Development Facilitation Team (DHO) – Review Comments

Project No: PR-2018-001579 **Date:** 7/30/2025 **Agenda Item:** #1 **Zone Atlas Page:** J-18, J-19

Request: Major Preliminary Plat review

Application For: MAJOR PLT-2025-00009 – MAJOR PRELIMINARY PLAT

TRAFFIC CIRCULATION  
LAYOUT APPROVED

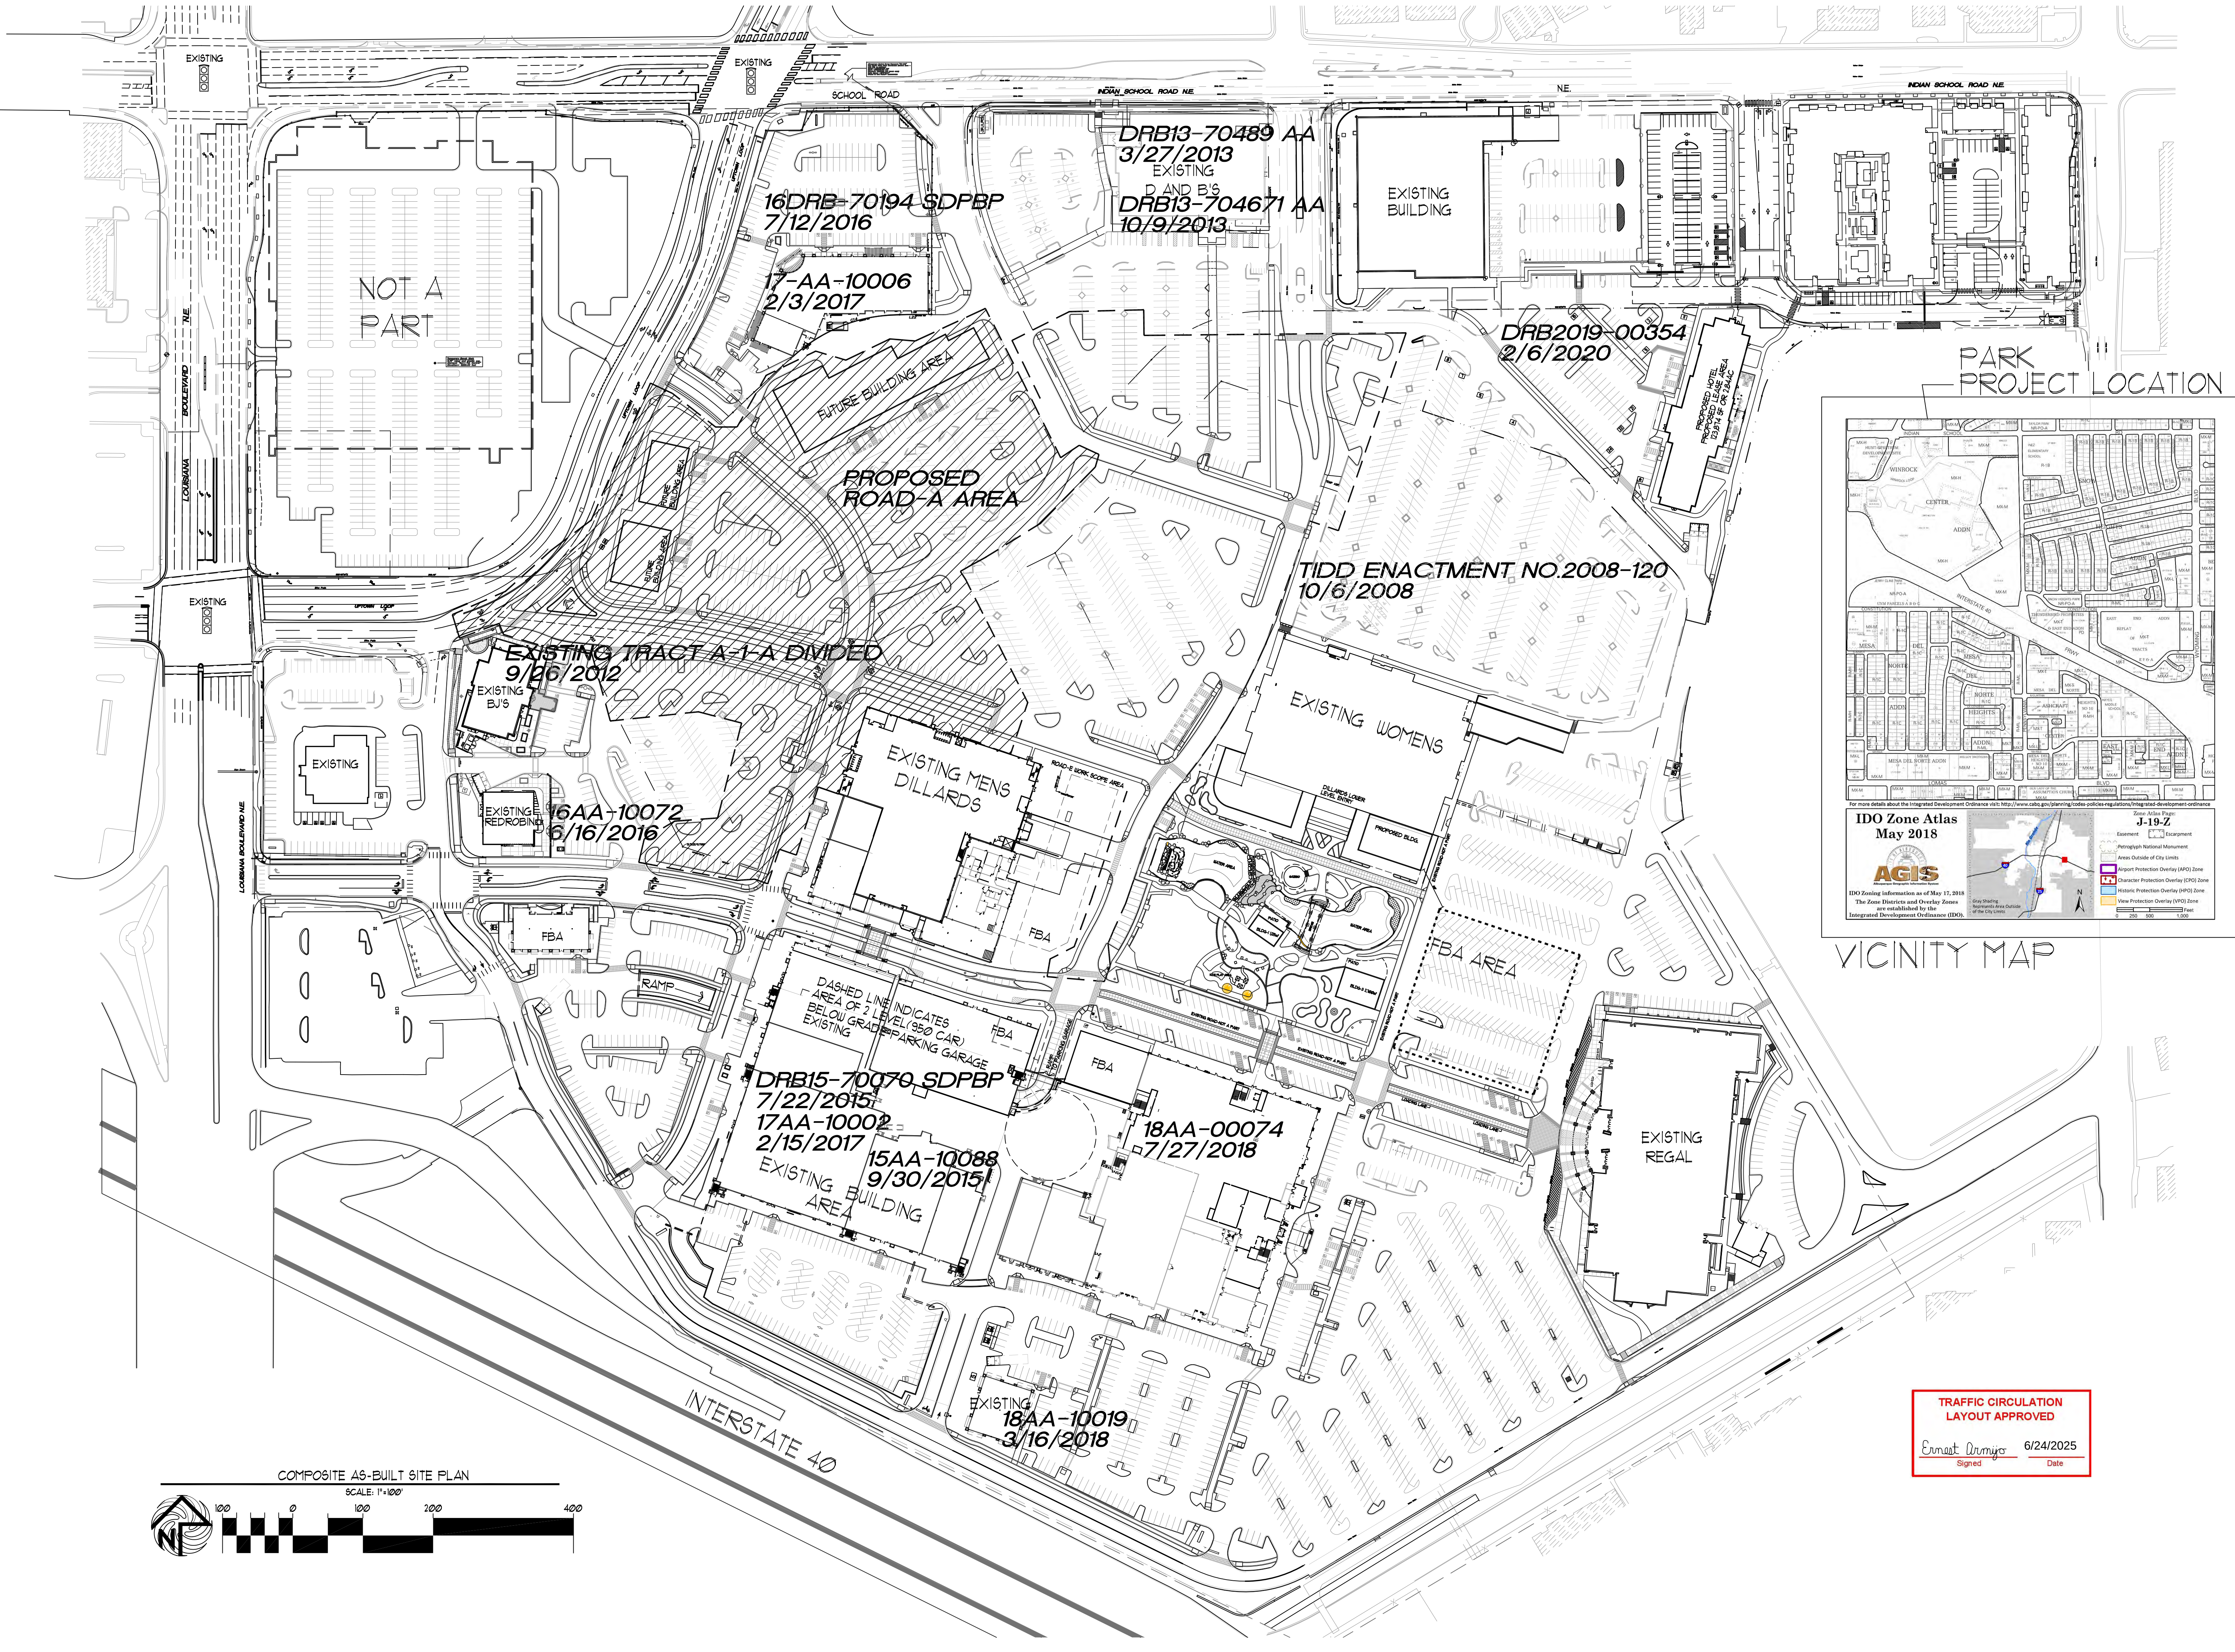
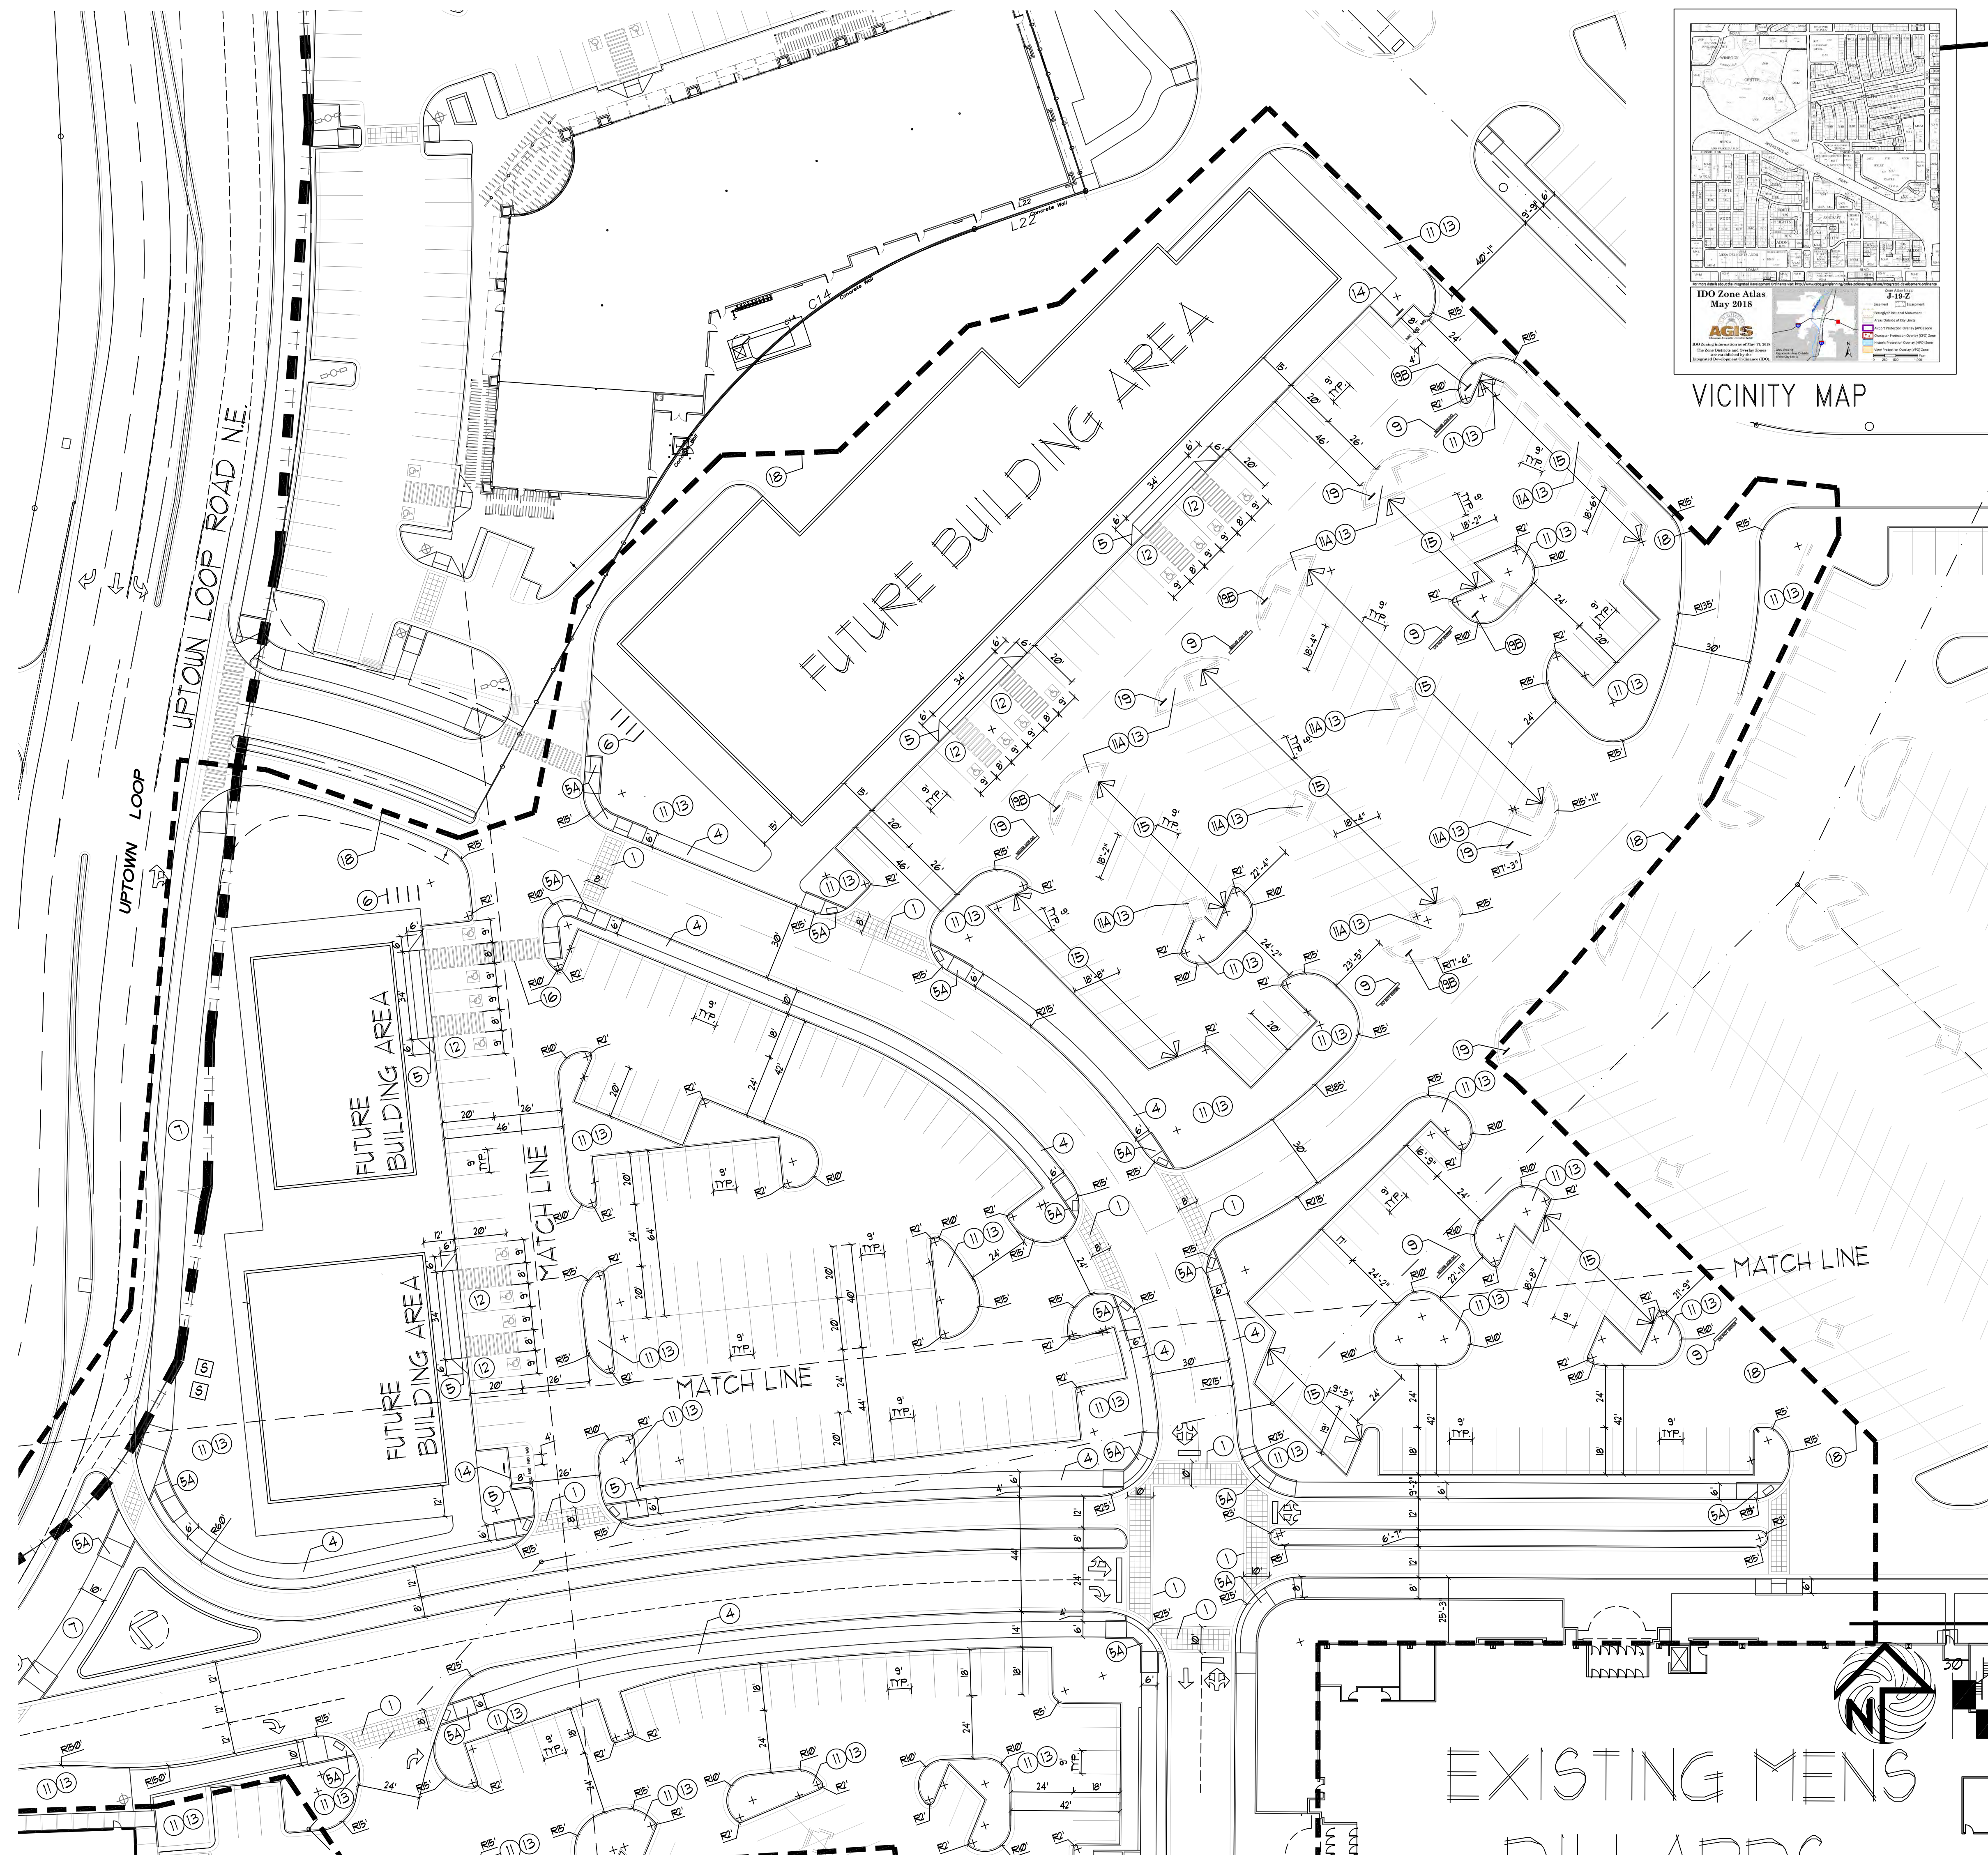
1. Your sidewalk exhibit only shows sidewalk interior to the site, but does not show widths on sidewalks along Louisiana or Indian School. Both are arterials within a center and require 10' sidewalks with 6' to 8' landscape buffers. Please show these widths to determine if widening is required.
